From: Ross McNaughton [REDACTED]
Sent: 03 April 2019 12:56
To: Planning
Subject: FAO Zak Denton re EP/23/19/HH

I note that Mr Haymes has contacted Arun DC by email dated 28th March 2019 in which he acknowledges 2 objections to his planning application re the caravan/car port. I am the neighbour at 41 Sea Lane he is referring to.

**UK
Planning
Maps**

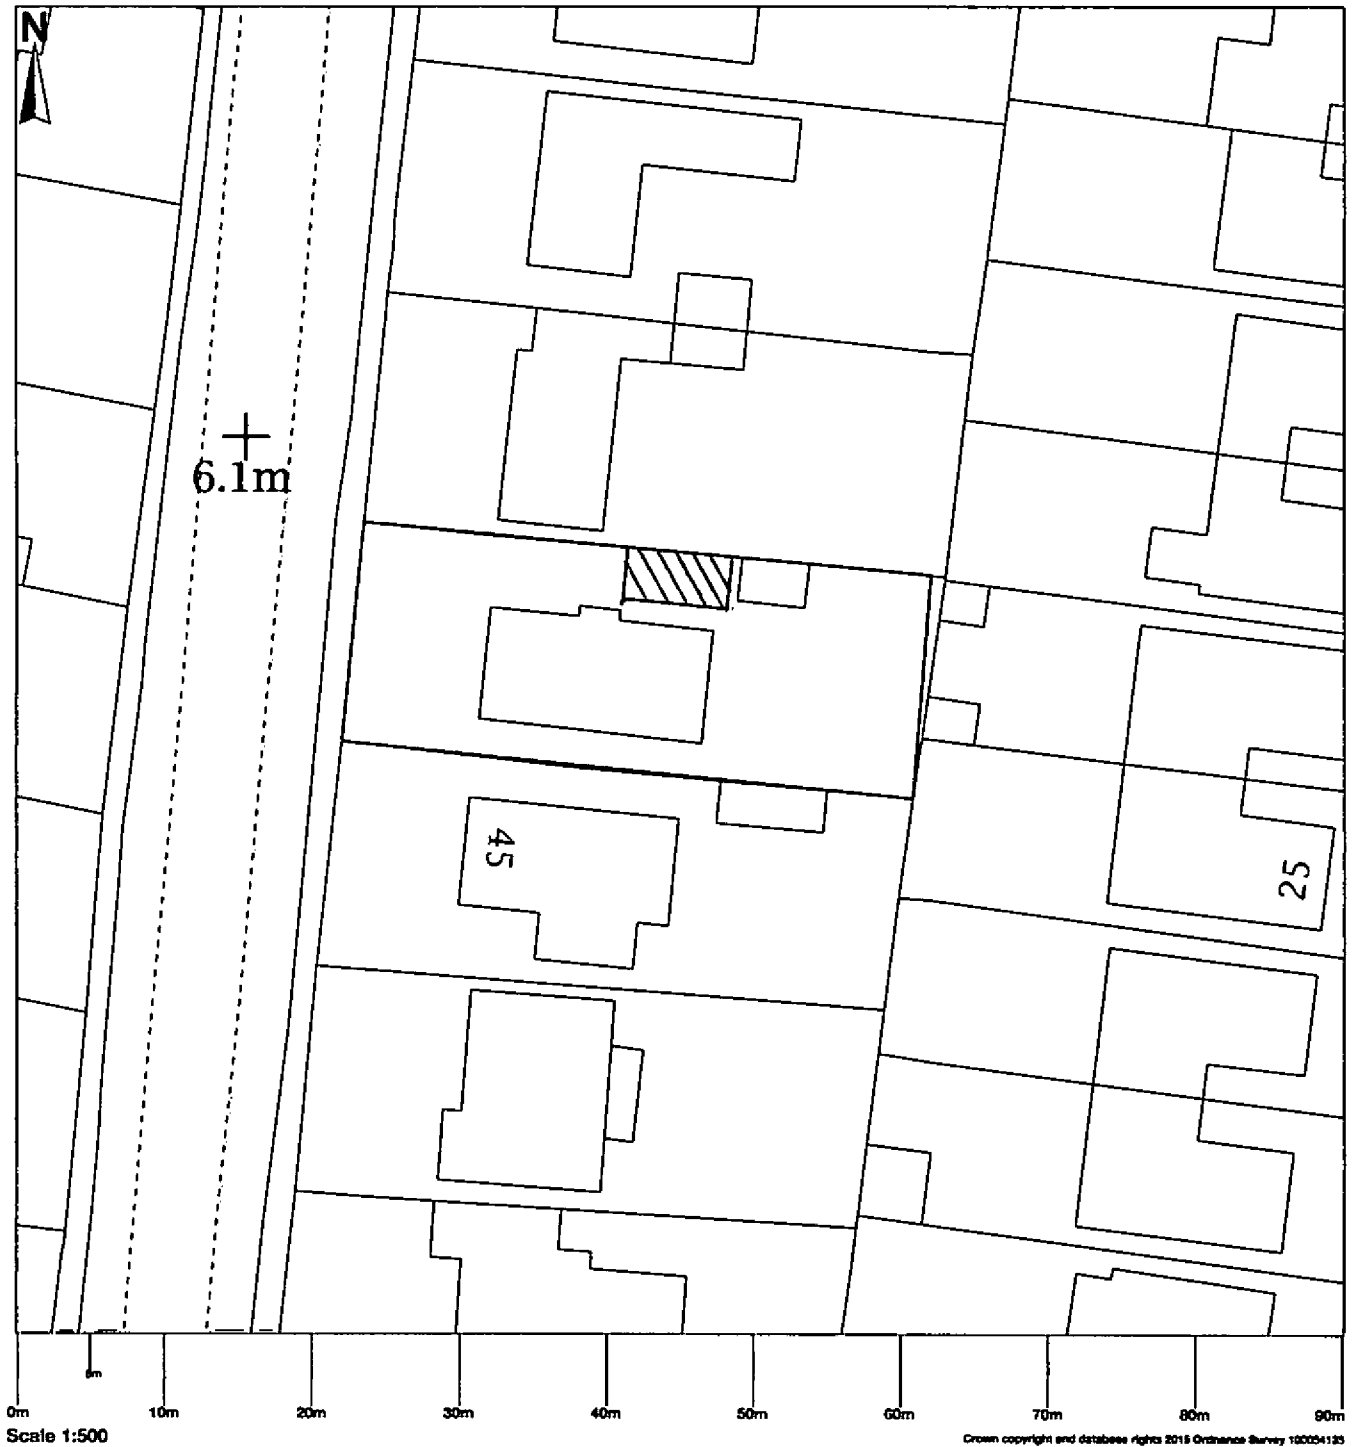
I want to add that the street plan that is attached to this planning application is out of date. It does not show the extension that was made to our property in 2016 which changes it from a rectangular shape to an L shape. This was reason of feeling hemmed in by the proposed structure.
